29 May 2026

TfNSW Reference: SYD24-00642/6
DPHI Reference: SSD-23480429

**MODIFICATION APPLICATION FOR ALDINGTON ROAD INDUSTRIAL ESTATE - (WESTGATE)
253-267 ALDINGTON ROAD - KEMPS CREEK**

**WATER MANAGEMENT PLAN**  
INTERIM STRATEGY

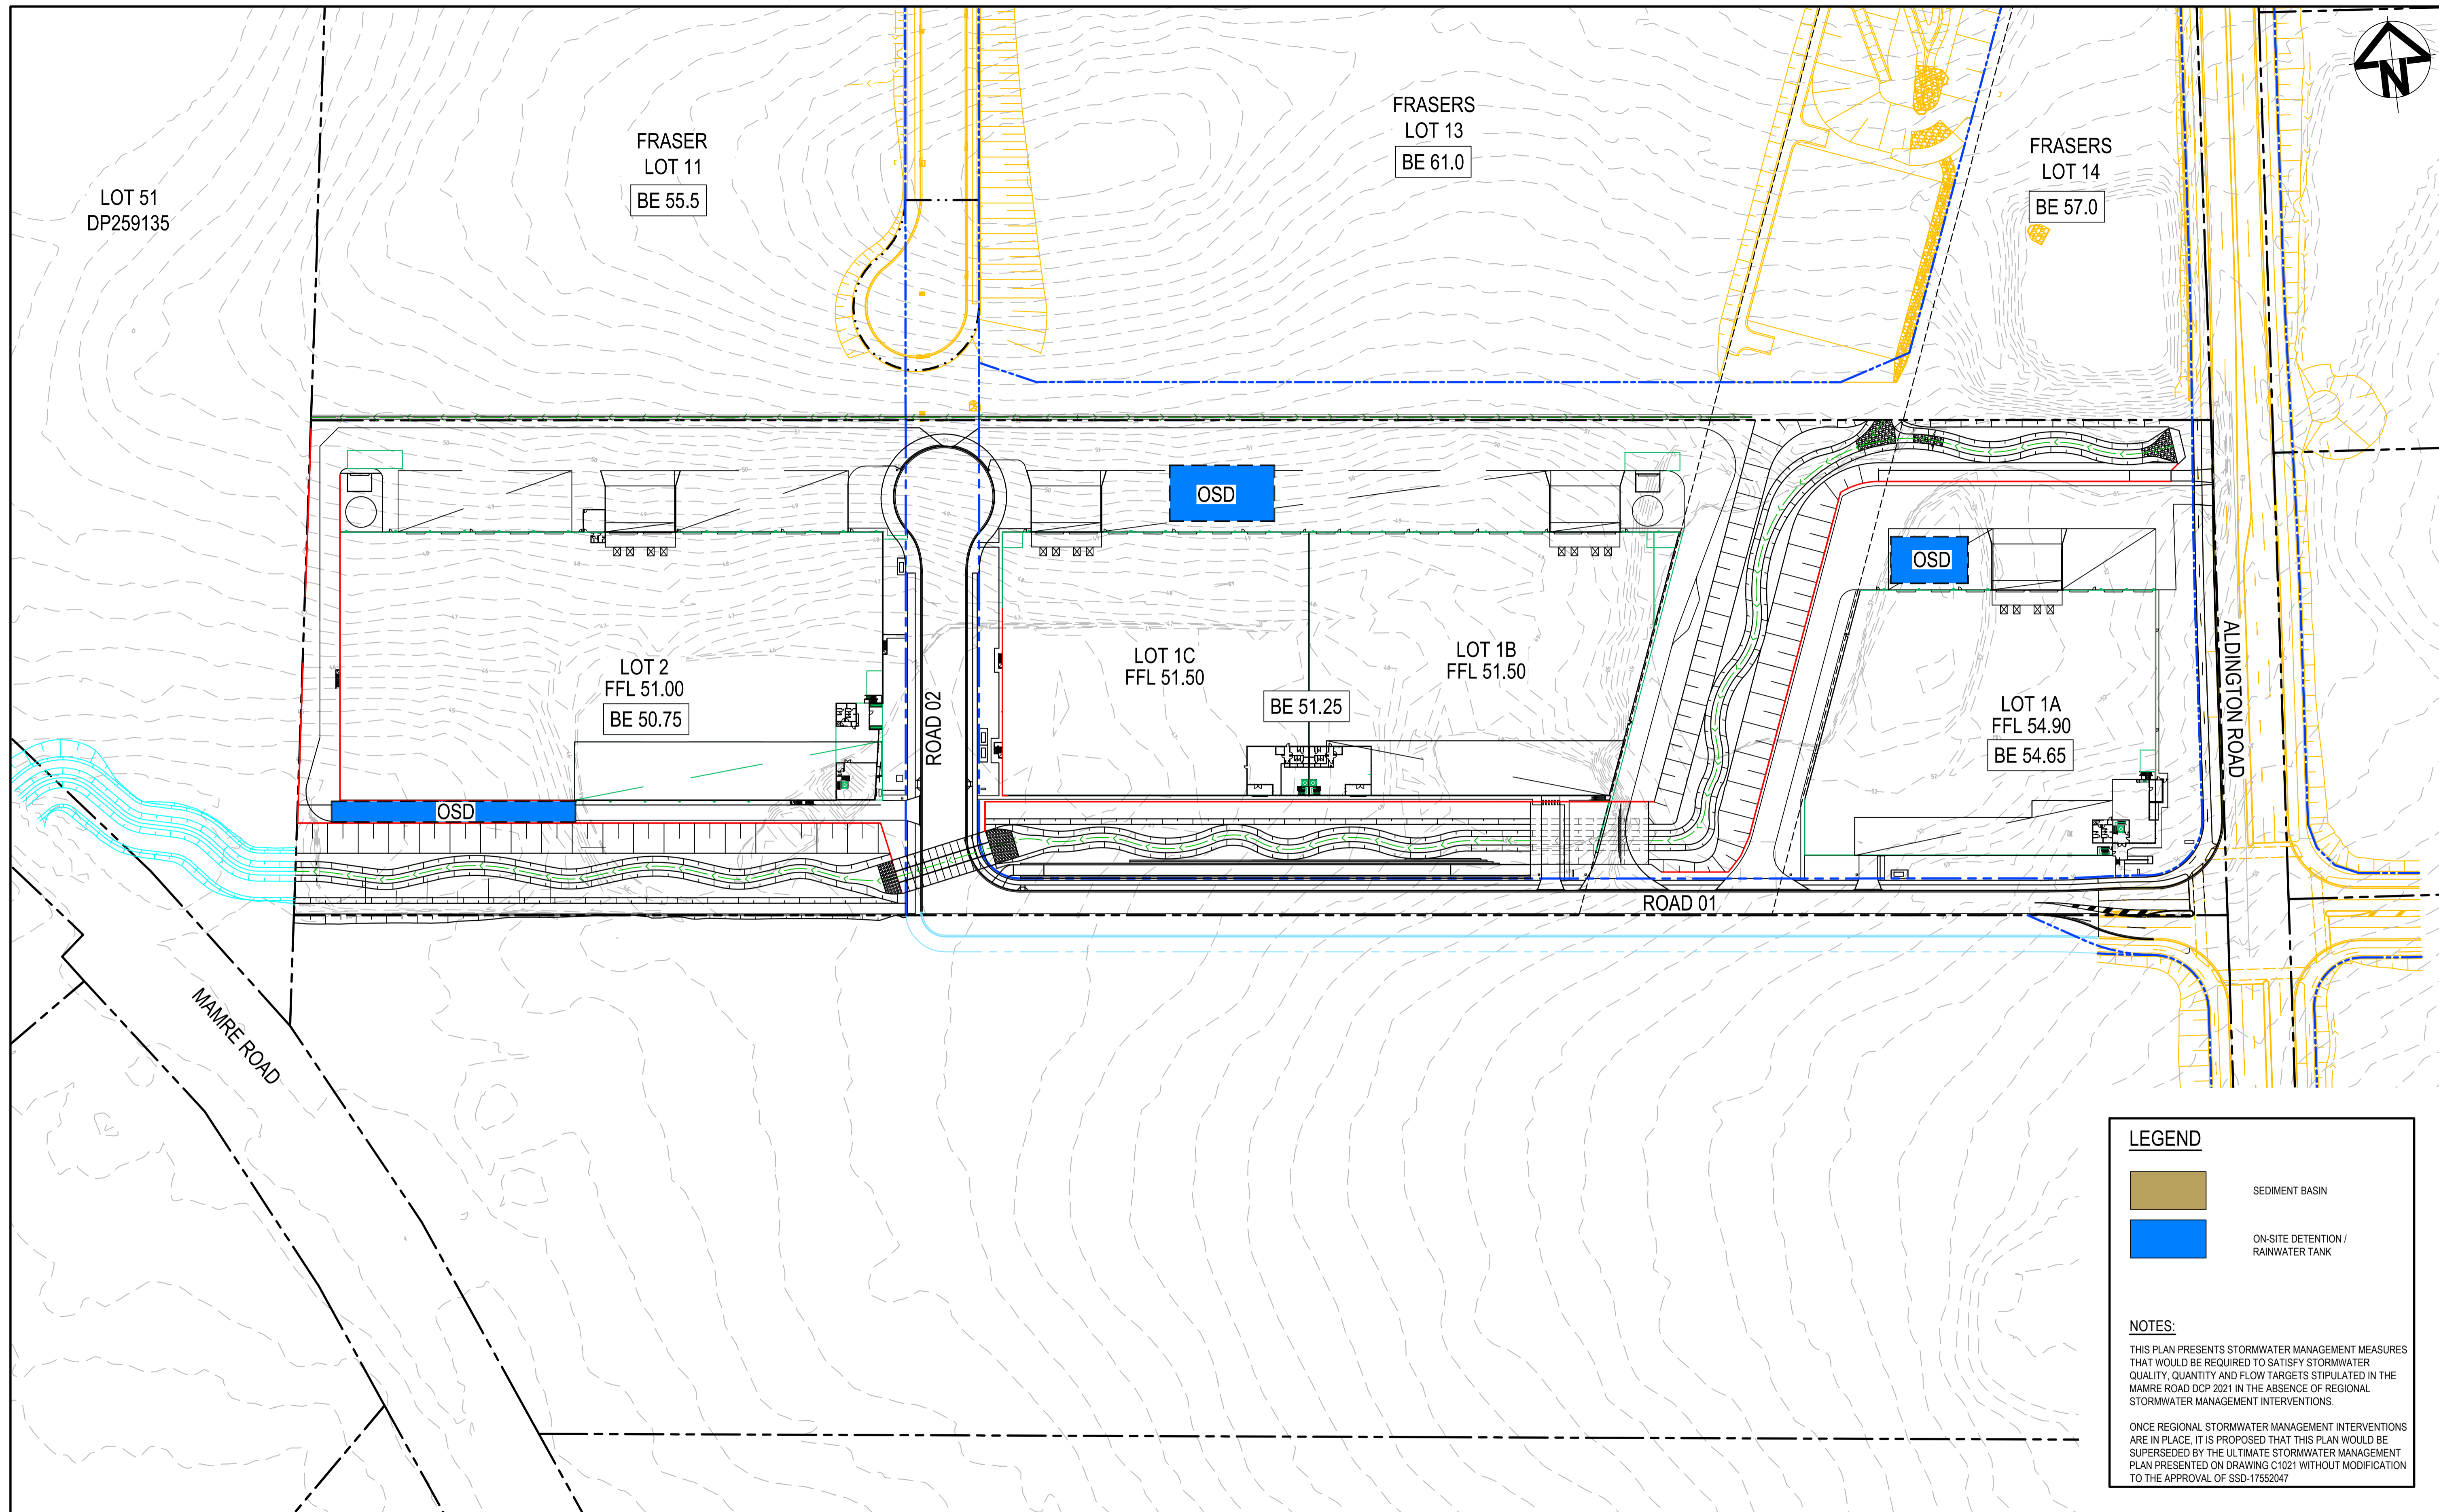
The ultimate stormwater management plan proposes an onsite stormwater detention prior to discharge into the Sydney Water trunk drain that connects via a culvert under Mamre Road to the future water recycling facility. As the culvert and water recycling facility is not yet constructed, an interim plan has been prepared to that manages the stormwater with infrastructure including an interim evaporation and reuse pond on lot 2 which will be used to irrigate the residual lot 2, and 50% of the adjacent trunk drainage channel.

TfNSW requires that the interim onsite stormwater detention constructed on Lot 2 be of sufficient capacity to ensure that the post development discharge of the site does not exceed the pre-development discharge of the site i.e. there is to be no increase stormwater discharge into the Mamre Road corridor.

WESTGATE KEMPS CREEK ROADWORKS PLAN

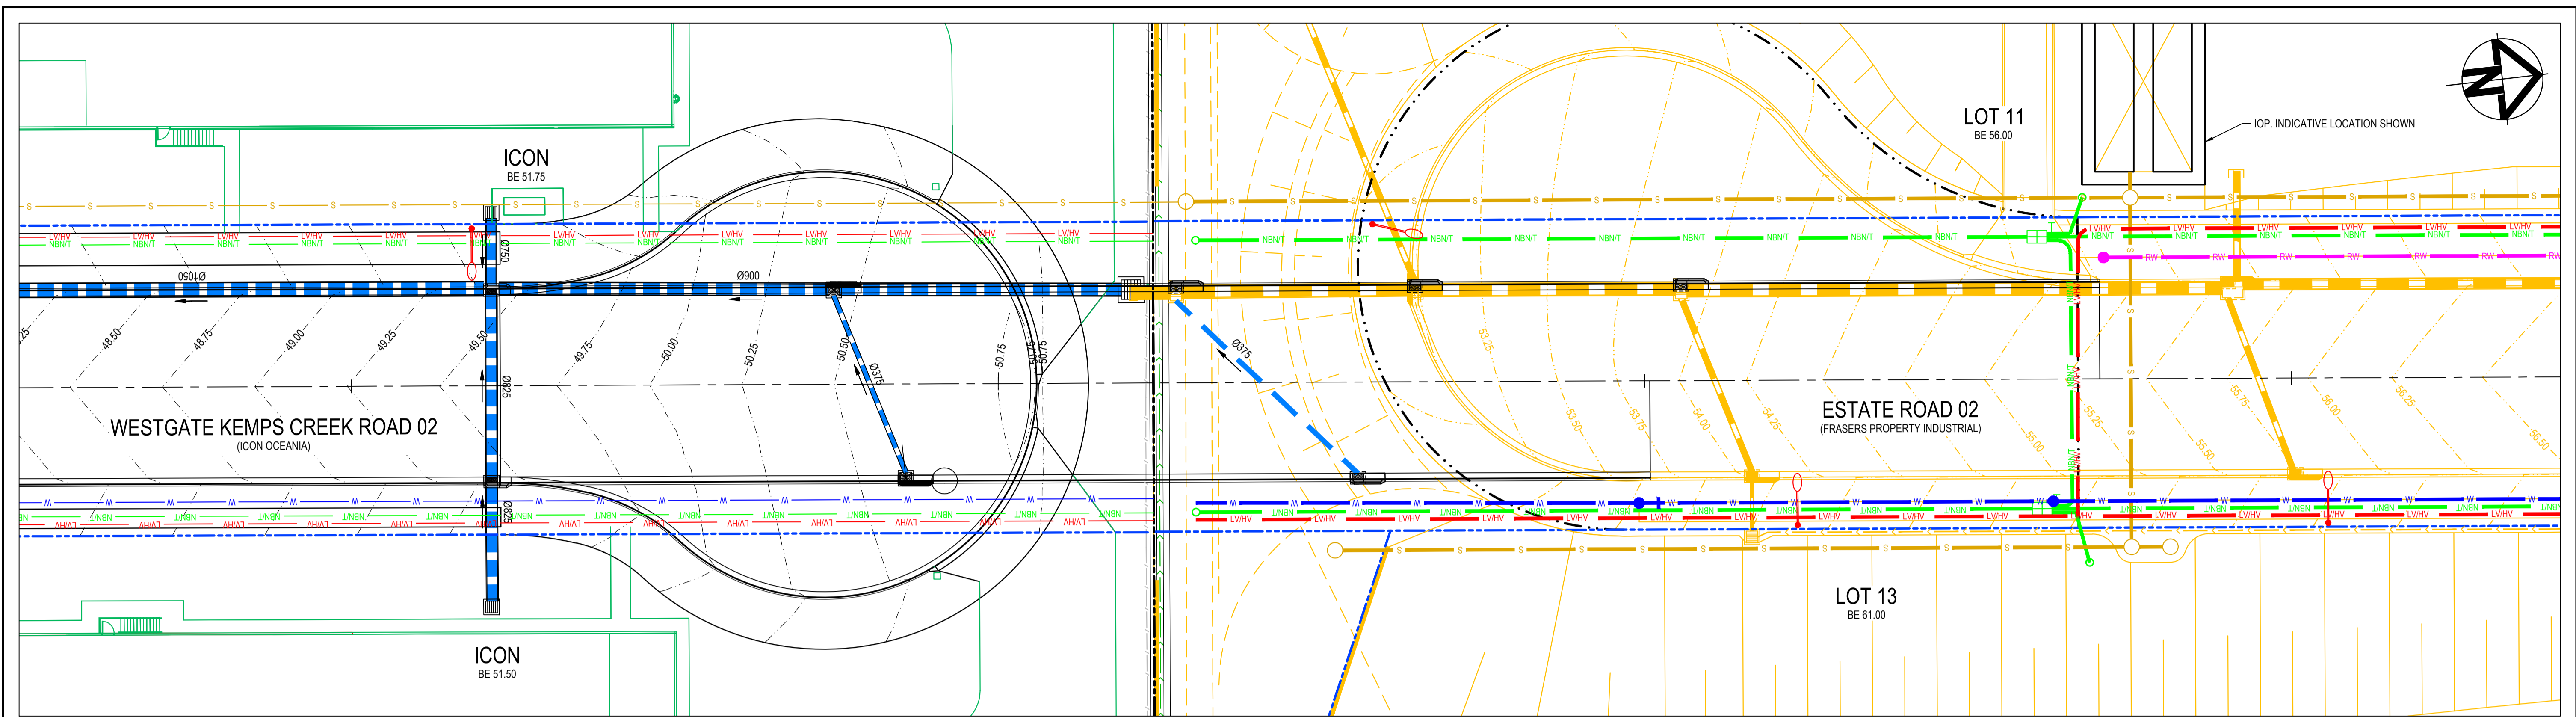
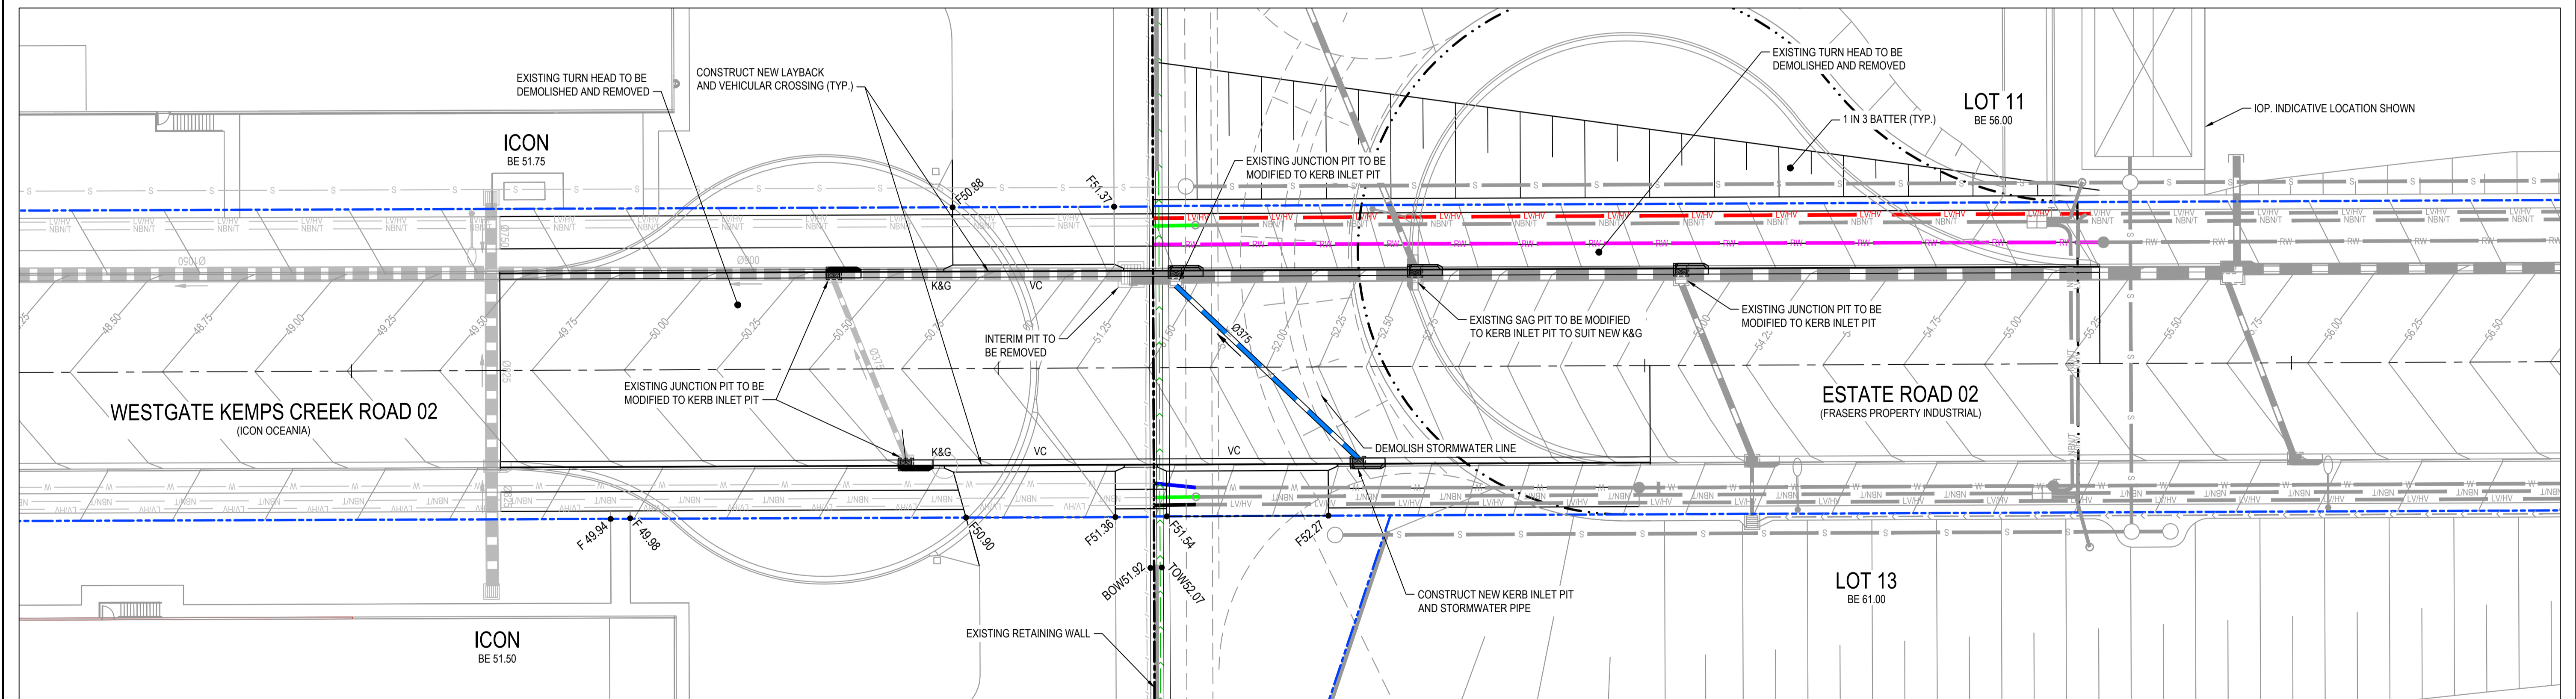
This site will obtain access from the future signalised intersection of Aldington Road/New access road (known as intersection 2 in the LOG East package of road works). LOG East are conditioned to deliver supporting infrastructure for the Mamre Road Precinct as shown in the image below.

TfNSW requires that prior to occupation of any warehouse within the 'Westgate' industrial estate, the following road works shall be completed:

- The intersection of Mamre Road and Abbots Road.
- Abbots Road widening between Mamre Road and Aldington Road.
- Aldington Road widening between Abbots Road to intersection 3.
- The traffic signal-controlled intersection of Aldington Road and intersection 2.
